PEAK GYMNASTICS

DESCRIPTION
LANDSCAPE
PLAN

SHEET NO.
L1.1

Markup Summary

**SITE PLAN**  
SCALE: 1"=30'-0"

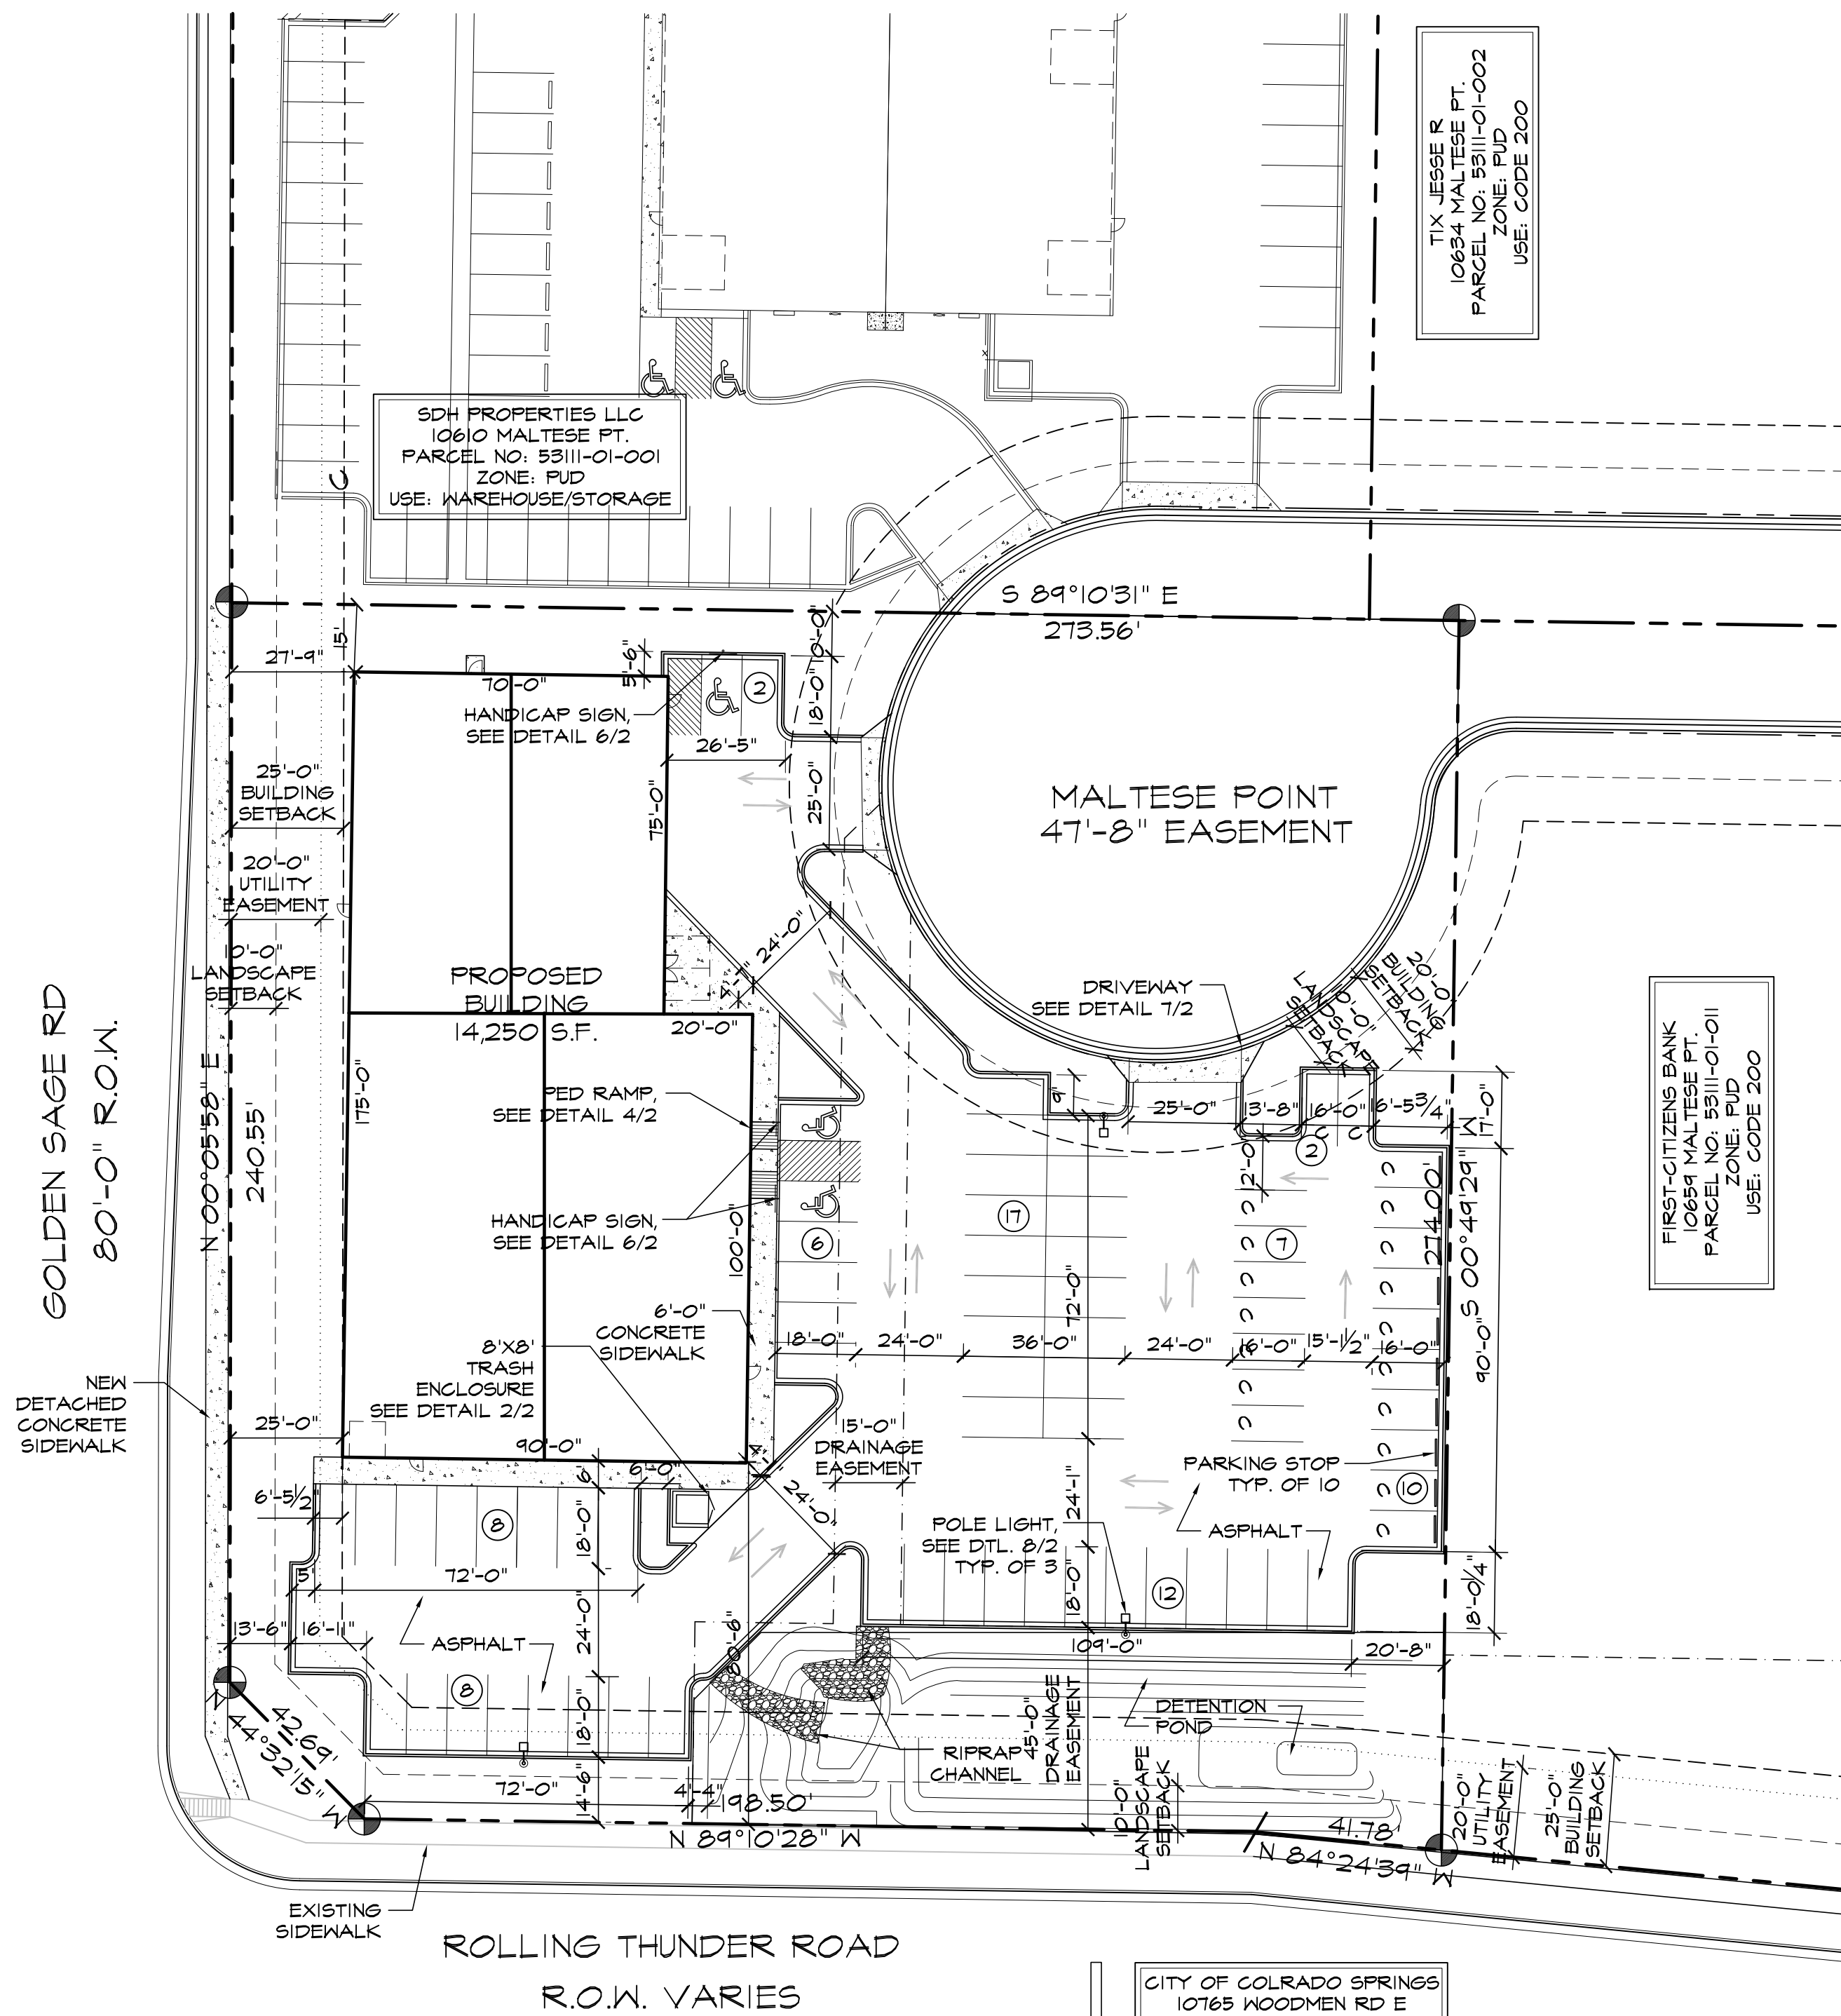
Subject: Callout
Page Label: 1
Author: dsdruiz
Date: 7/23/2018 1:55:48 PM
Color: ■ outside of property line

Subject: Callout
Page Label: 1
Author: dsdruiz
Date: 7/23/2018 1:59:29 PM
Color: ■ parking adjacent to the ROW requires a minimum of 30" screening.
